Re: Bango Wind Farm (SSD 6686)

Thank you for the opportunity to comment on the proposal by CWP Renewables on the Bango Wind Farm.

Figure 33
Photomontages
locations

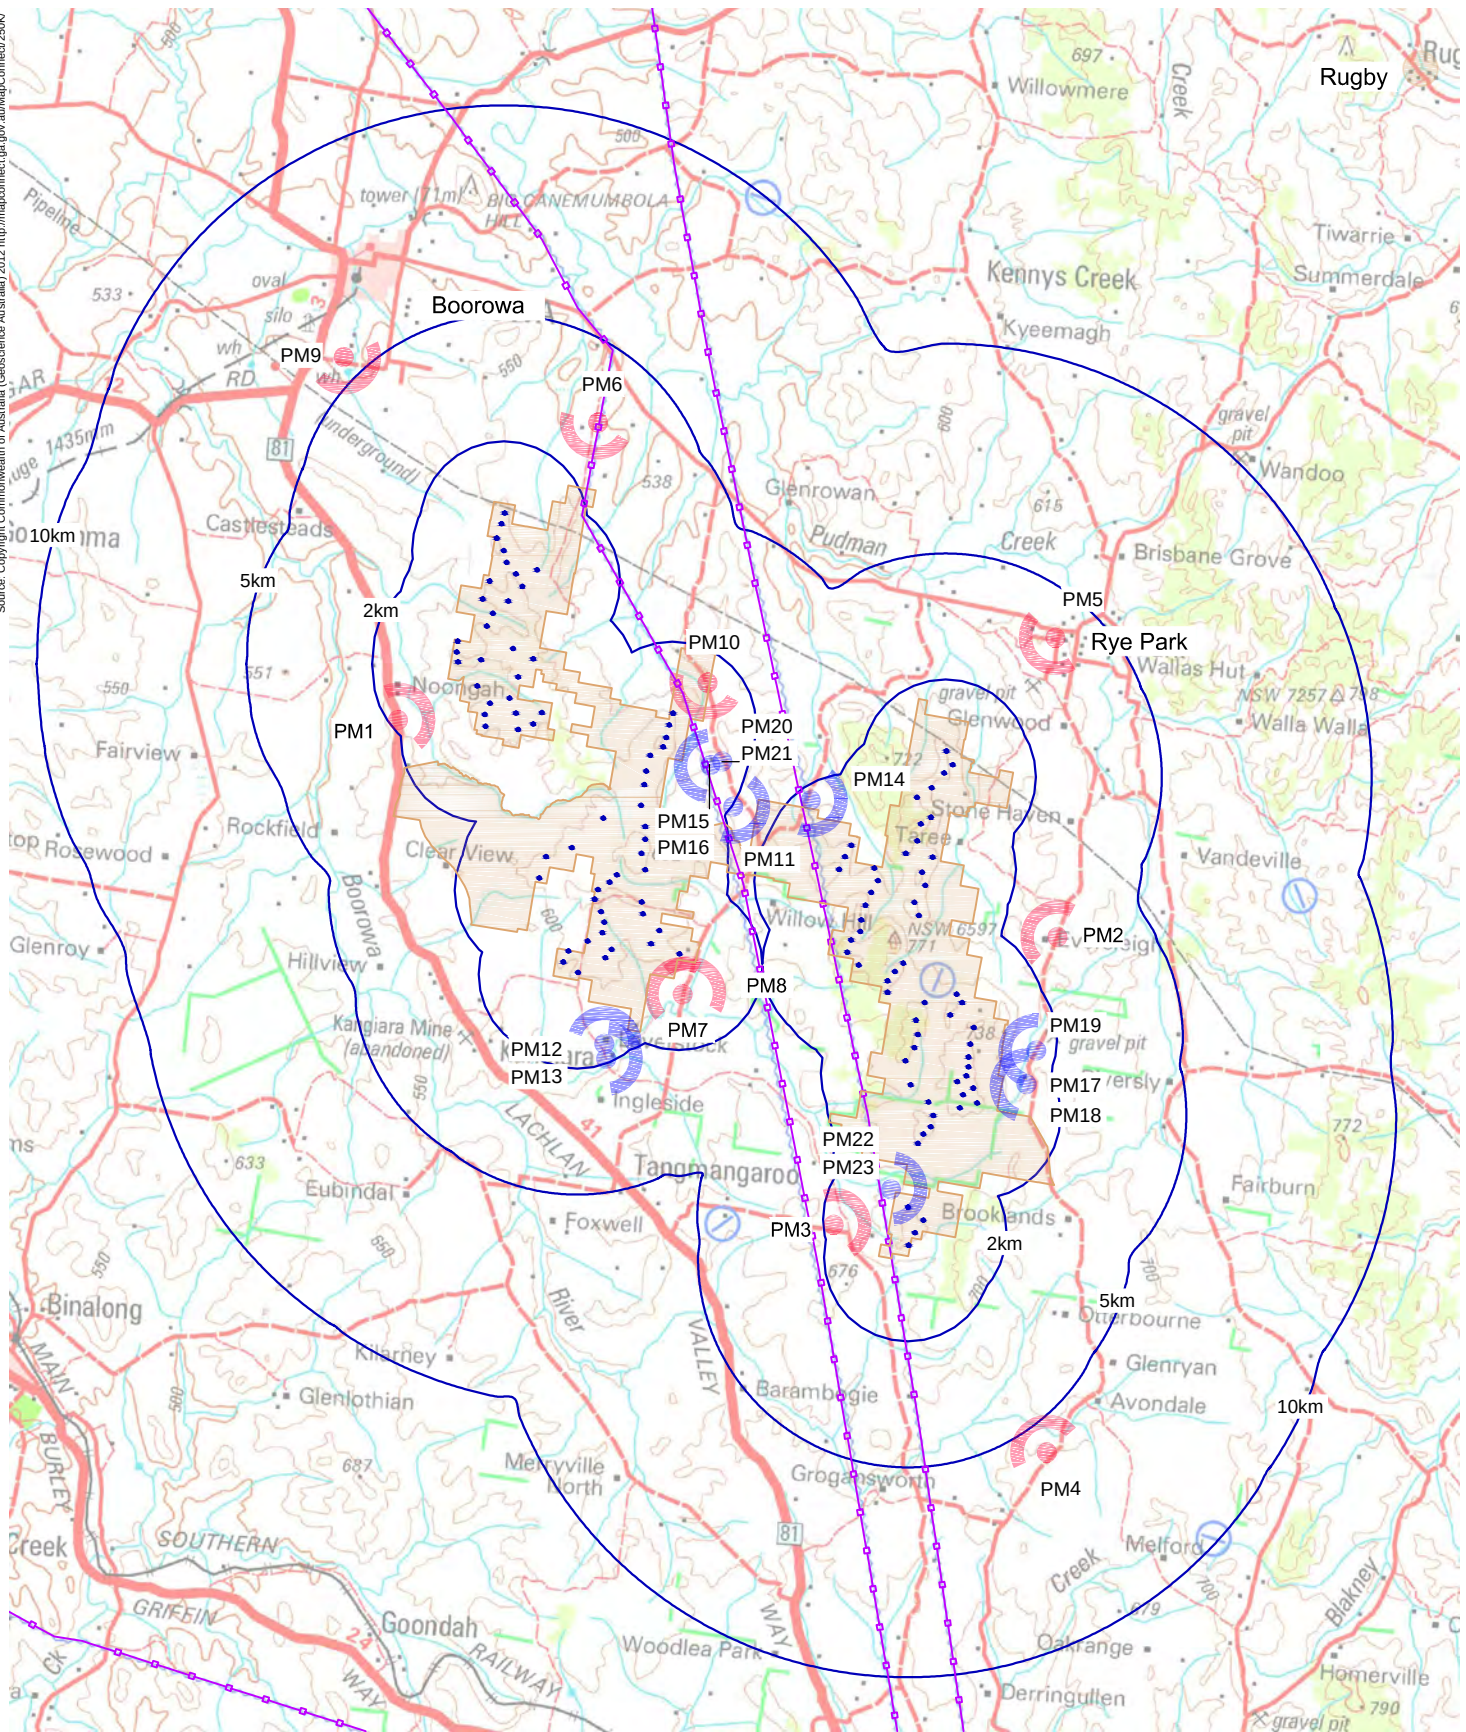
Other areas of concern about the information day were the lack of photomontages from the township of Boorowa, even though there is one in the EIS, and no photo montages from the Rye Park Road between Boorowa and Rye Park. I was also alarmed to see Charlie Prell of the Australian Wind Alliance with a stand at the information day. Australian Wind Alliance have a relationship with CWP Renewables, and have a campaign currently running to gain favourable submissions for the Bango Wind Farm, and I hope these template submissions from other areas of the country and the world will be scrutinised accordingly. At the CCC meeting of 26th October 2016 Siobhan Isherwood, Project Manager, admitted that CWP Renewable have made financial contributions to Australian Wind Alliance in the past, saying that most recently they had paid Australian Wind Alliance for a bus trip to the Taralga Wind Farm.

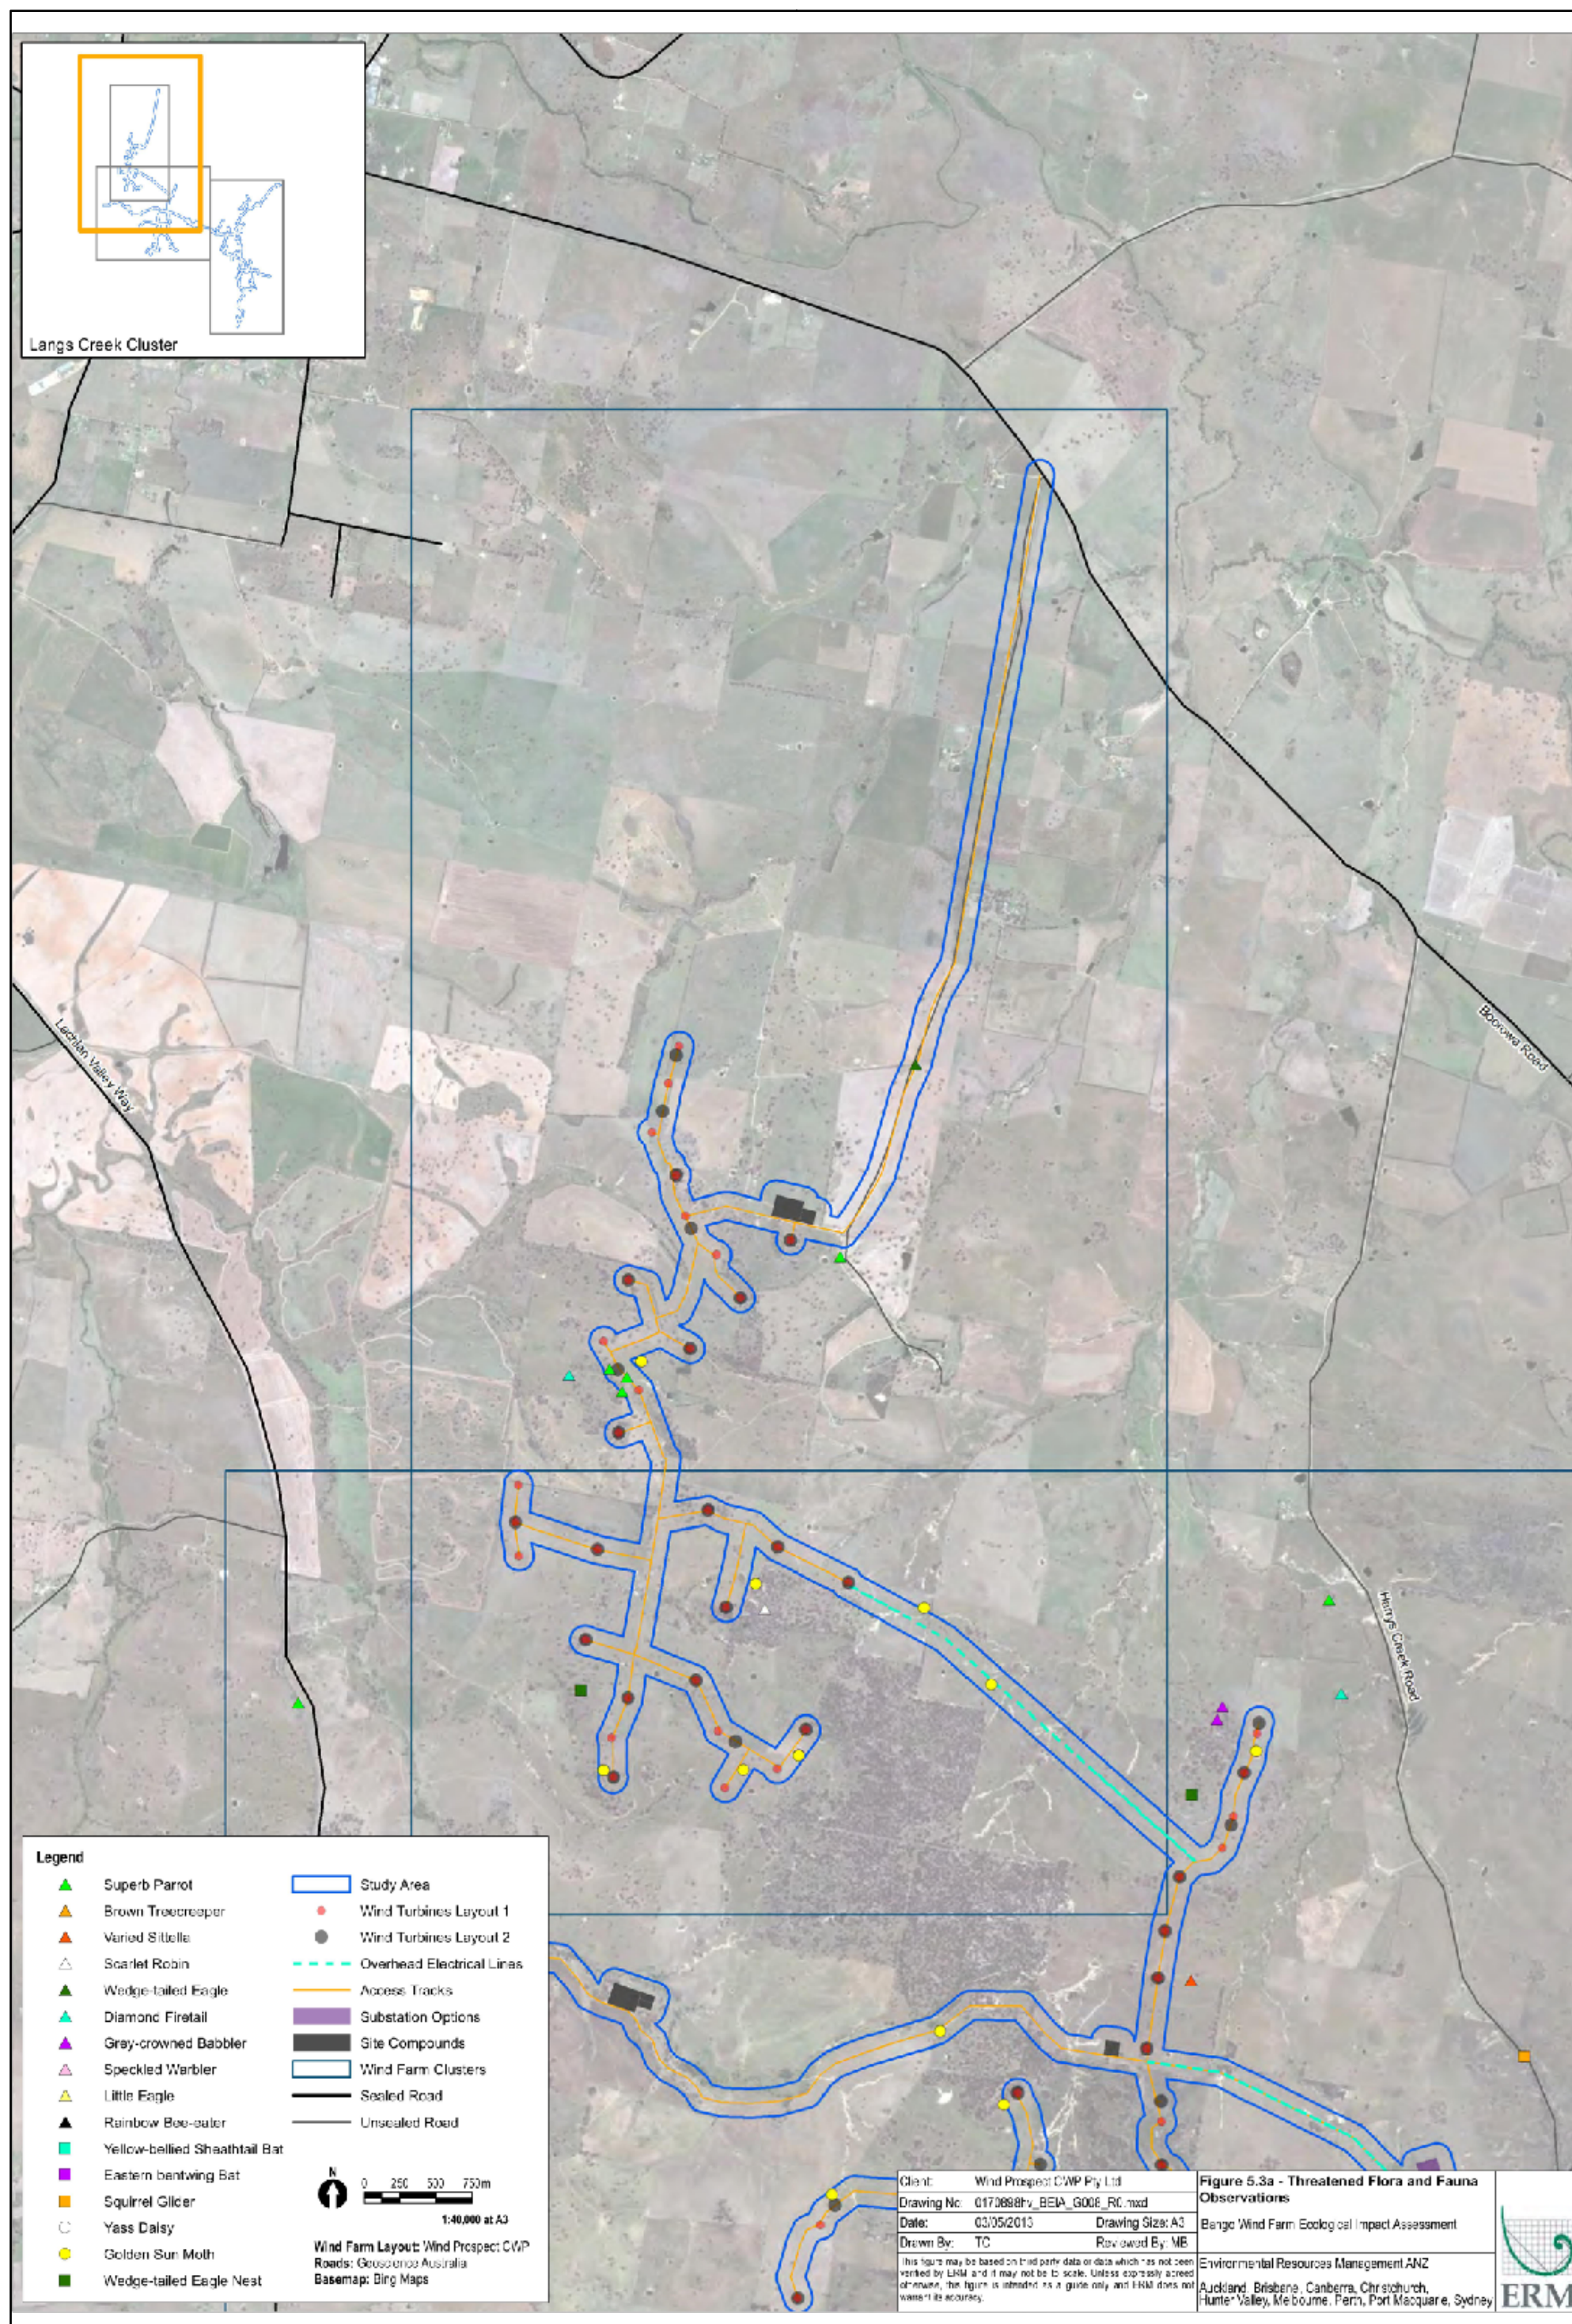
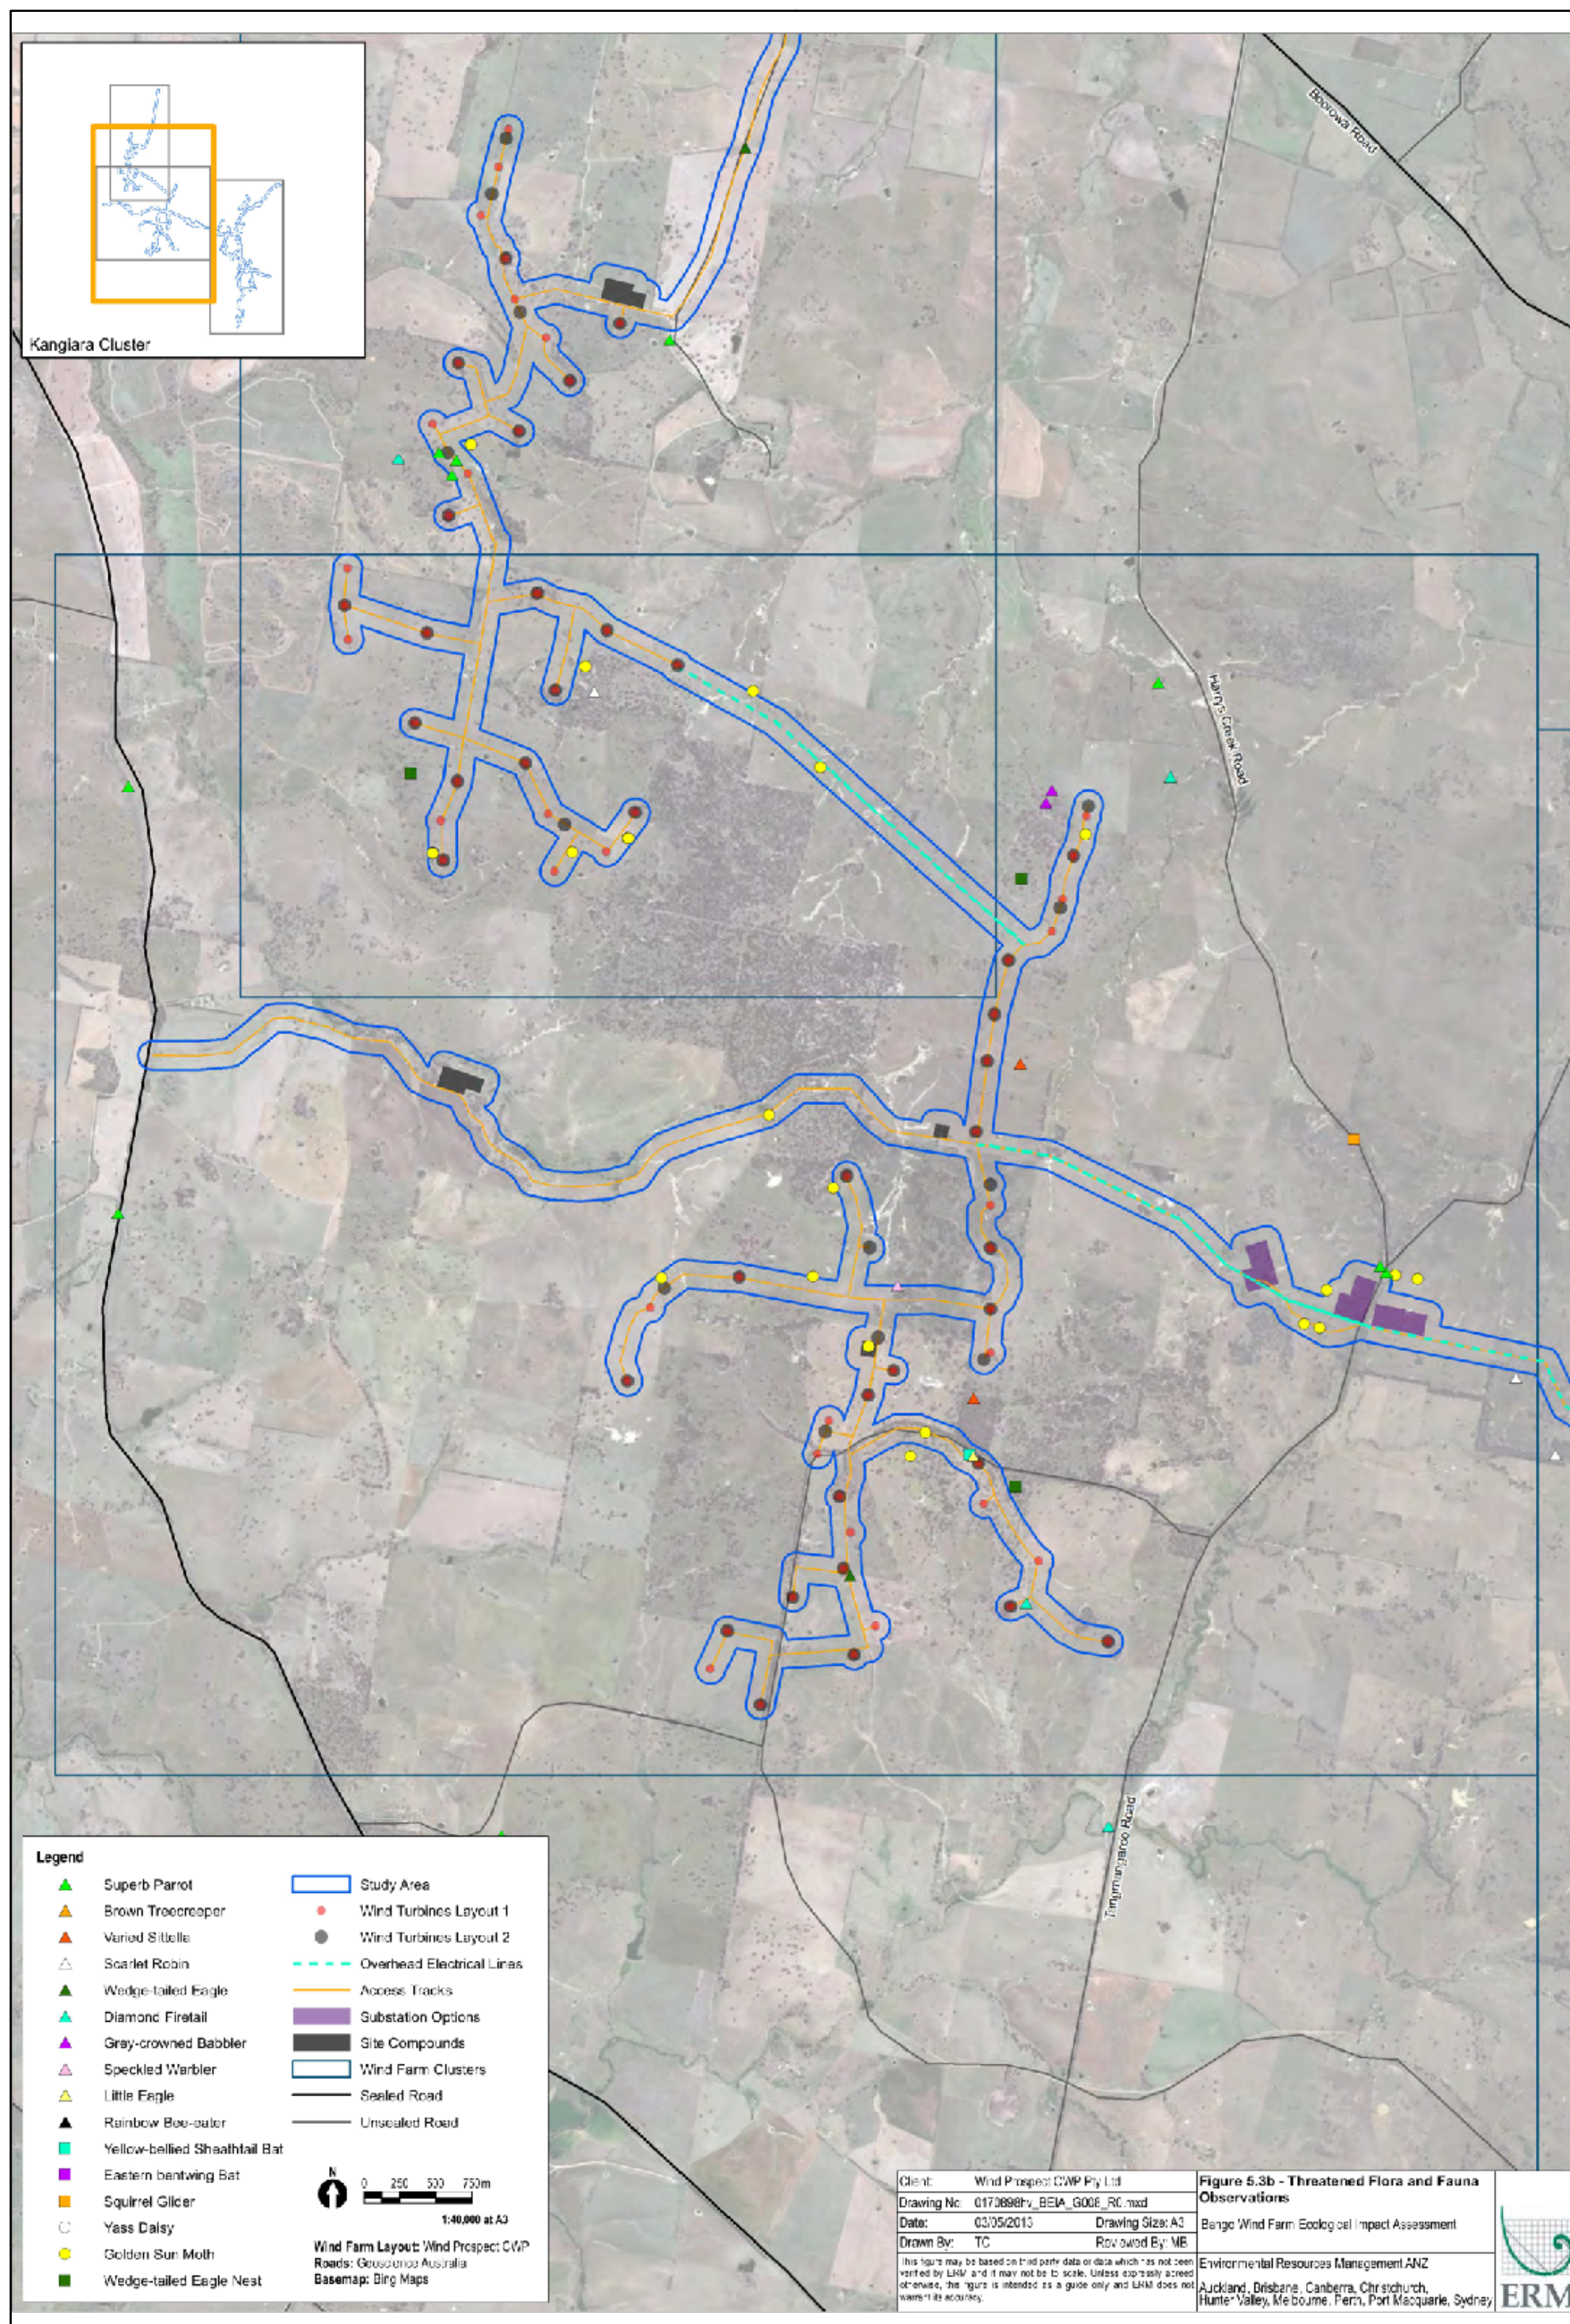
- Page 207 lists the large number of 'Fauna Groups' in the proposal area. Will this be taken into consideration?
- Page 212, figures 10.11, 10.12, and 10.13 Threatened species tables. These are dated 3/5/2013. If this is the date of surveys they would not have found many Superb Parrots around at this time of the year and needs clarifying. And again surely studies more recent than 2013 could have been found to more accurately indicate the current story.
